From: Martyn White
Sent: 21 June 2019 10:50
To: Planning.Responses
Cc: Zac Denton
Subject: A/41/19/PL

A/41/19/PL

The proposal consists of two elements; a new porch and works to a car port/garage area.

GARAGE – PROPOSED FLOOR PLAN (1:50)

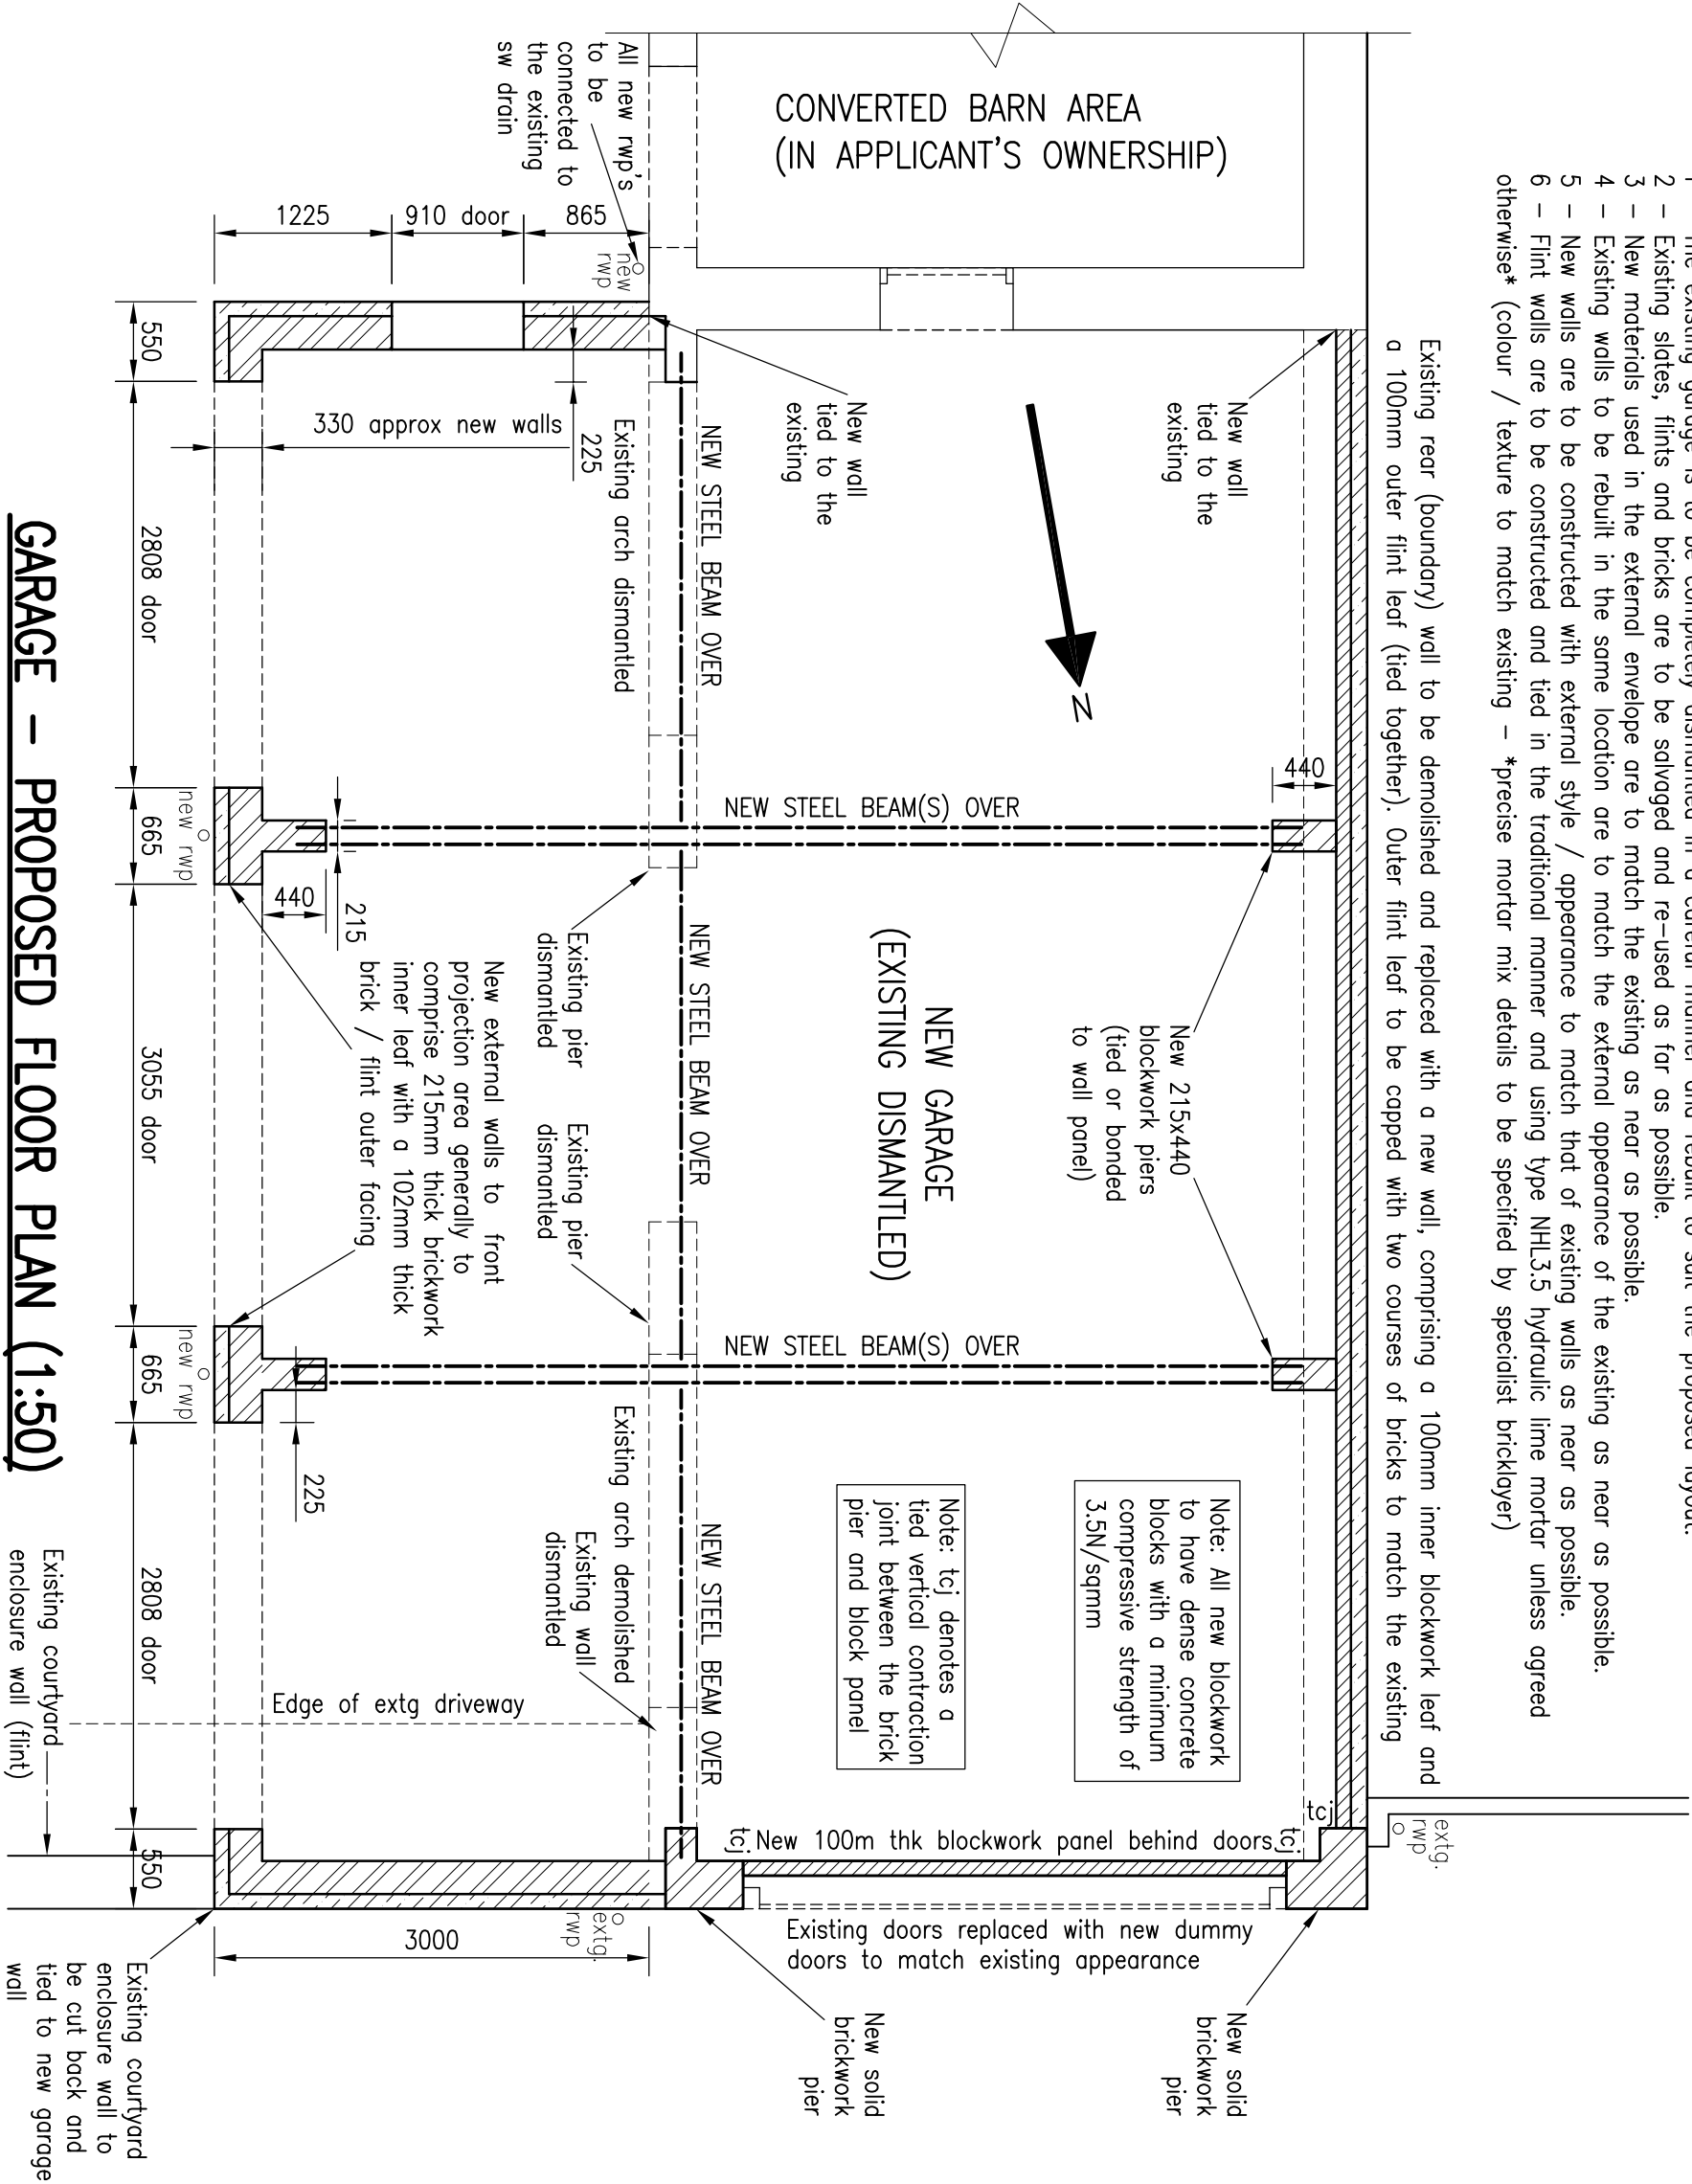
Is the application to extend the existing car port structure or as the DAS states, to dismantle the existing garage and reconstruct a replacement, with an extension? If it is the later, the description of the works is incorrect, and misleading.

I note that for the works to the car port/garage is to essentially extend part of one of the single storey wings to provide more accommodation. The area proposed to be extended/alterd forms a covered parking area with an older garage door fronting directly on to the street. When I previously visited the site I noted that the area has already been extensively rebuilt, and that there is limited historic fabric remaining. It is worth noting that the proposal will also affect a stretch of the existing, attractive flint wall which encloses the courtyard. This proposal would be visible from the lane to the front of the site.

Whilst altered, the wing is fairly simple in nature reflecting its subservience to the main element of the dwelling. The extension would alter the building line, and bring a section of it forward. This has the potential to create a more complex elevation, which if not treated correctly would affect the simple character of the building. I note that the intention is to replicate the existing elevational treatment, which would enable the new works to reflect the character of the host dwelling. Such a proposal is acceptable as it would ensure that the development reflects the character of the building and there would be a neutral impact upon the character of the local area.

GARAGE – PROPOSED ROOF PLAN (1:50)

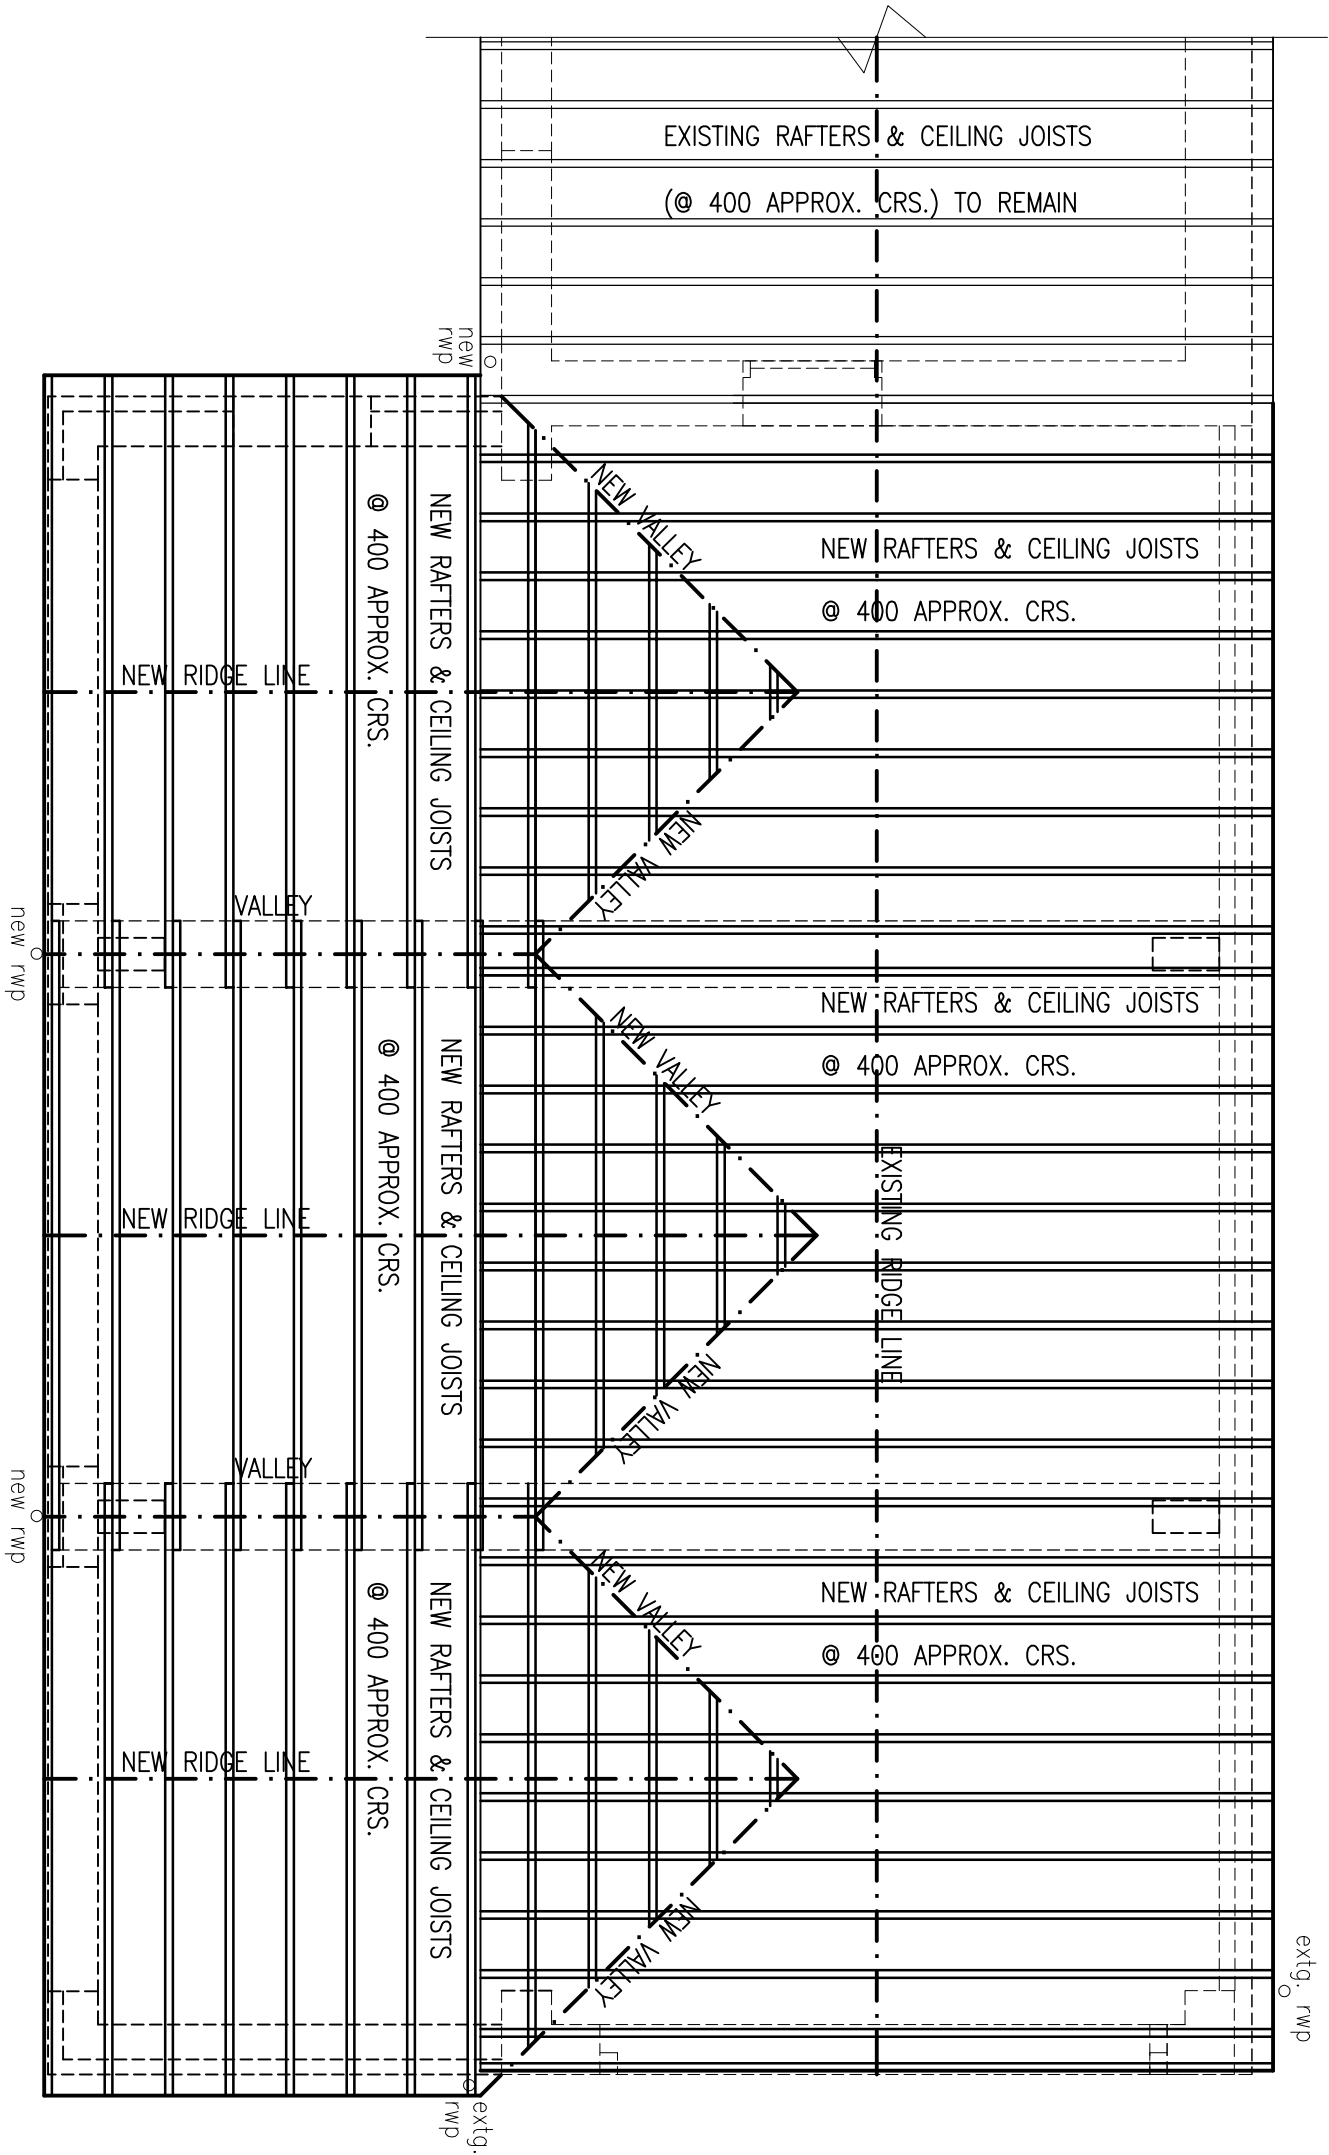
Traditional materials would be essential to reduce the impact of the proposal on the host dwelling, including the use of flint work and traditional garage doors. Flint work could not be used in pre-constructed concrete blocks; it would be required to reflect the quality of the existing, traditional work. Existing design details would have to be replicated to a high standard. You may wish to condition these items in order to secure a high quality development.

DRAWING TITLE
Proposed Porch –
Front Elevation of Existing House
Showing the Proposed Porch

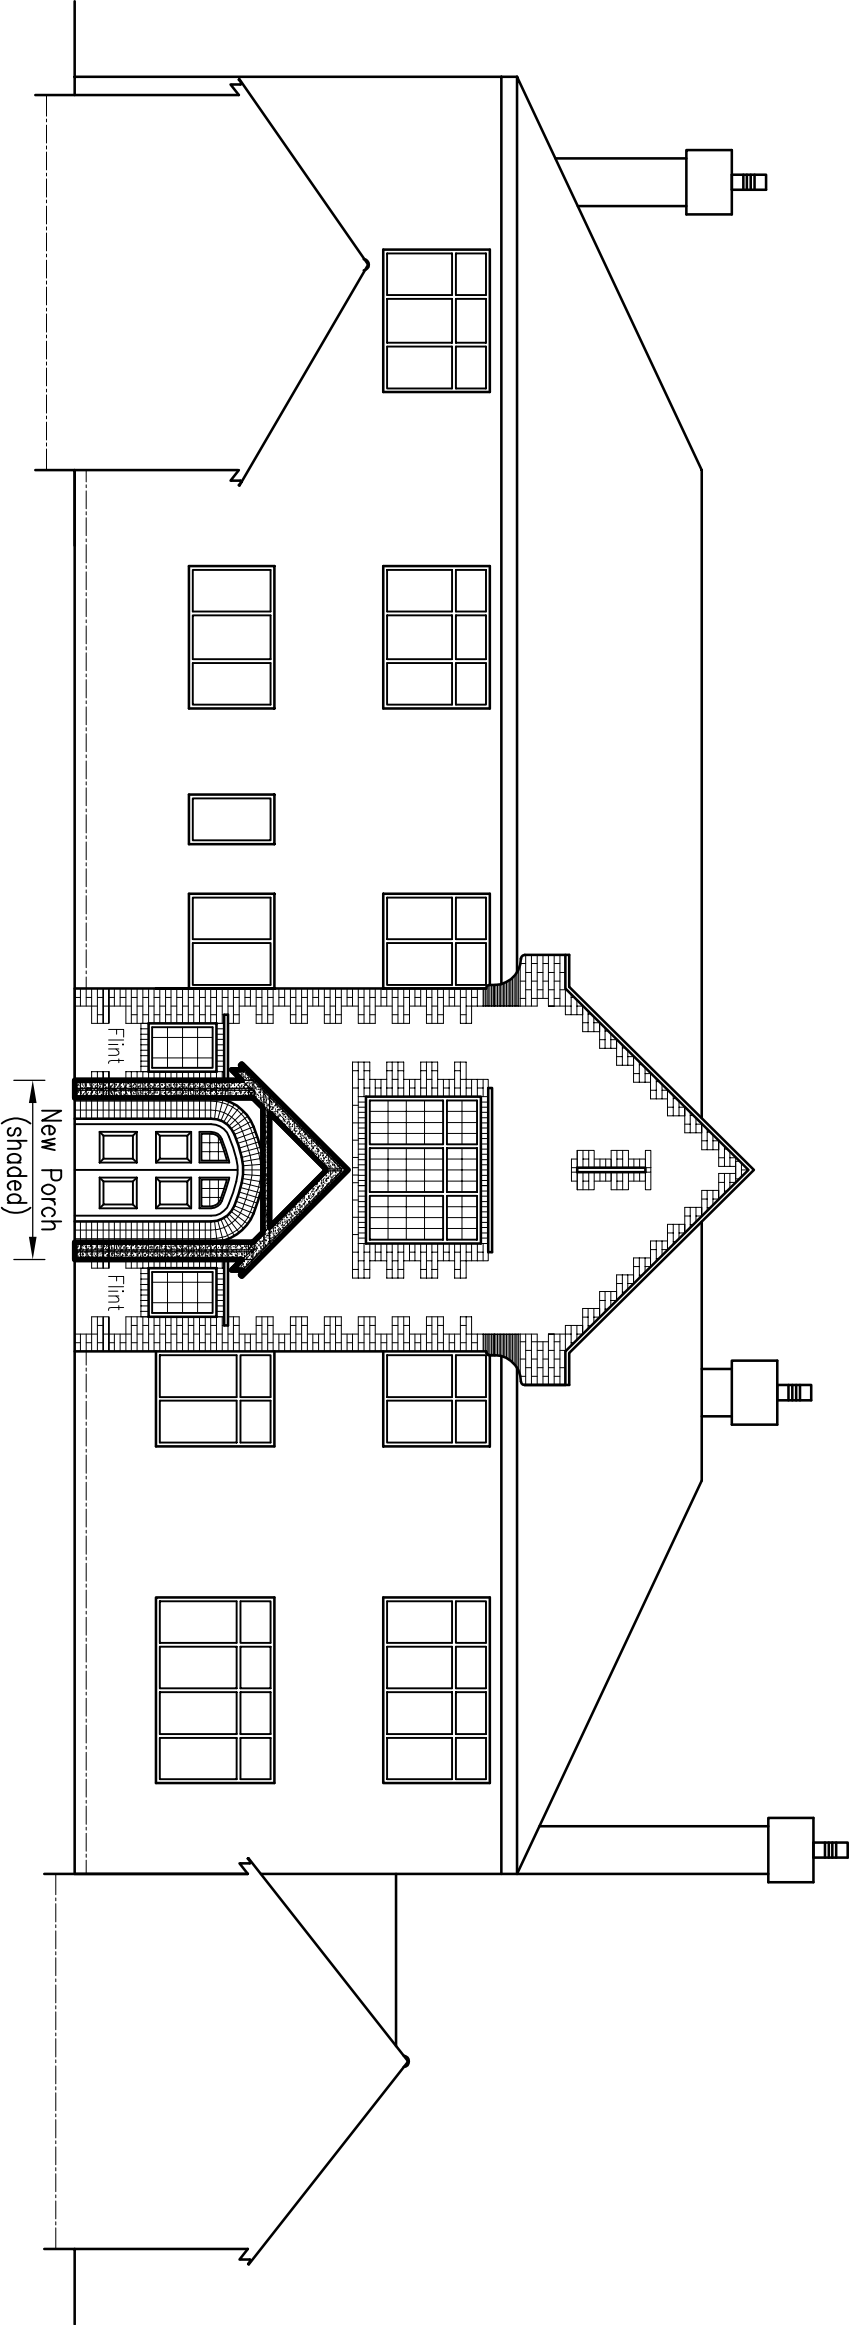
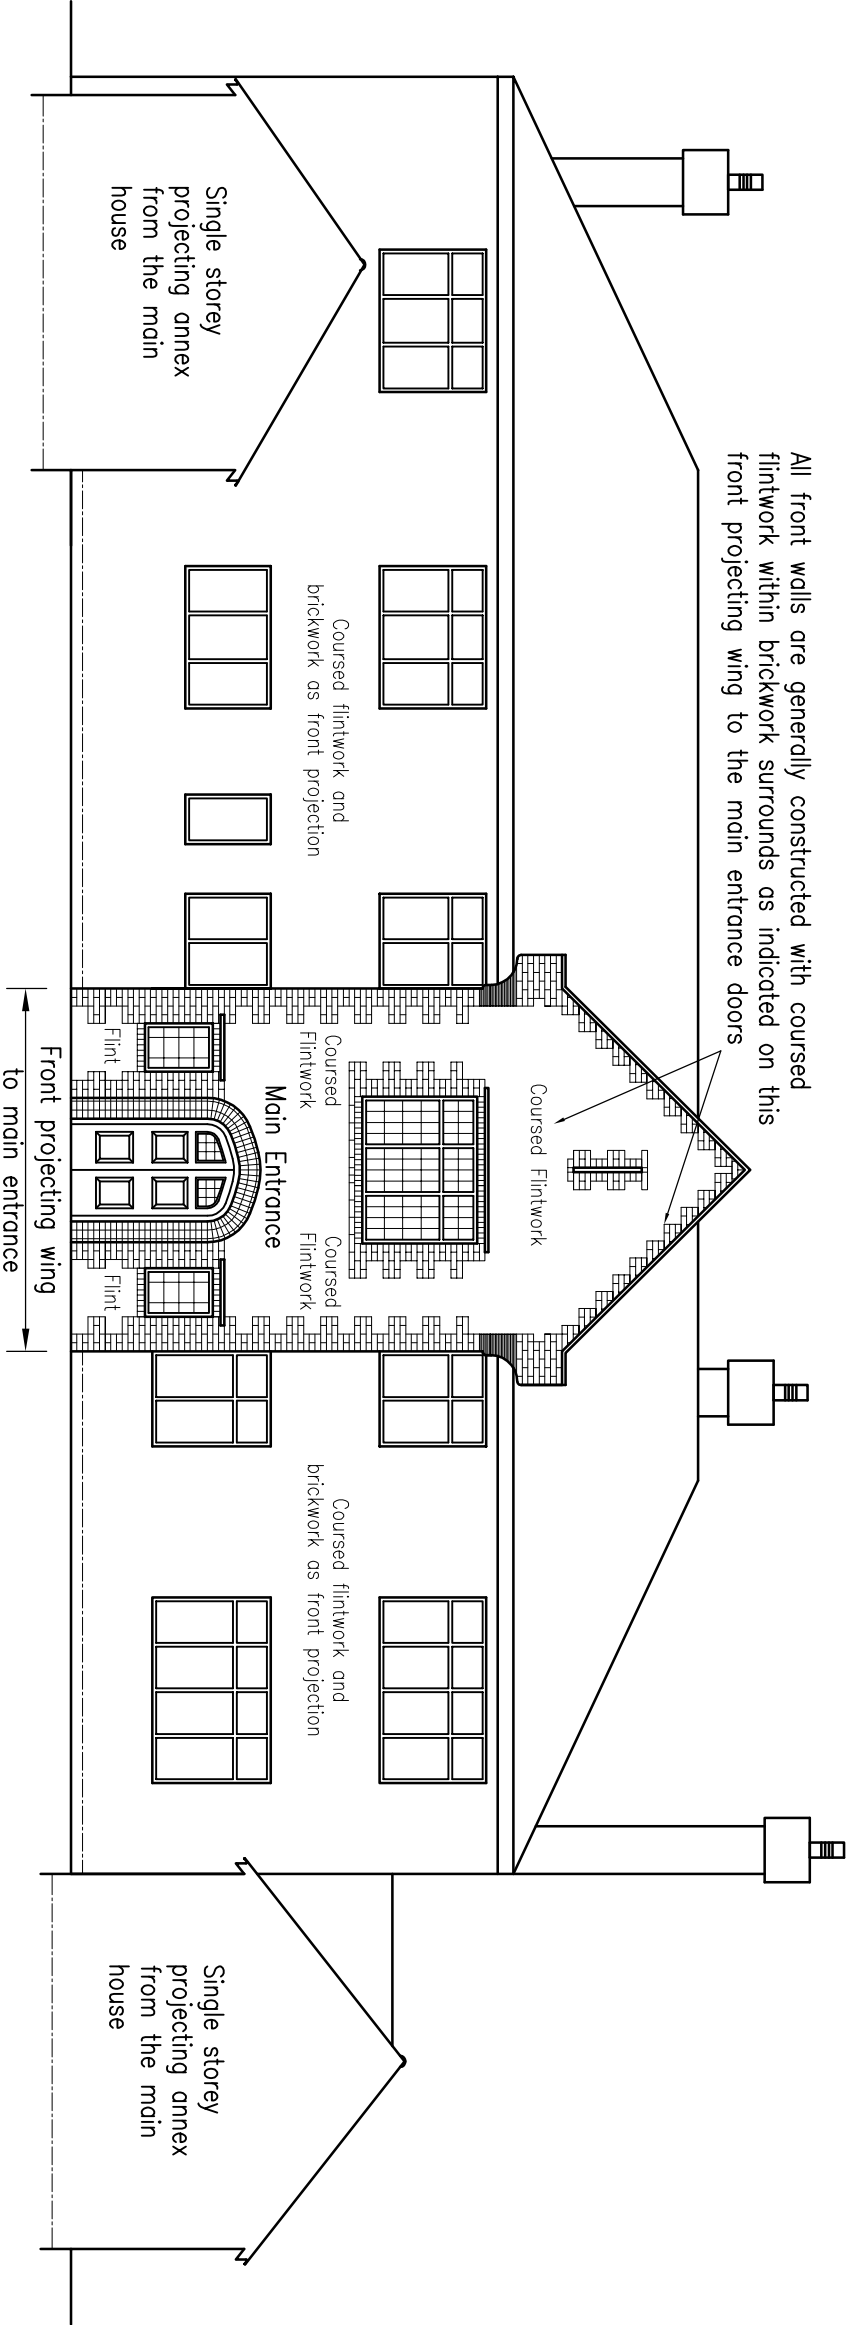
The porch is simple in character and appears to be designed to reflect the appearance of the host dwelling. This is visible in the use of brick/flint and like for like windows. The use of a glazed elevation is somewhat problematic as it introduces an element which is not fully sympathetic with the house. However, it will allow for the attractive door to be seen.
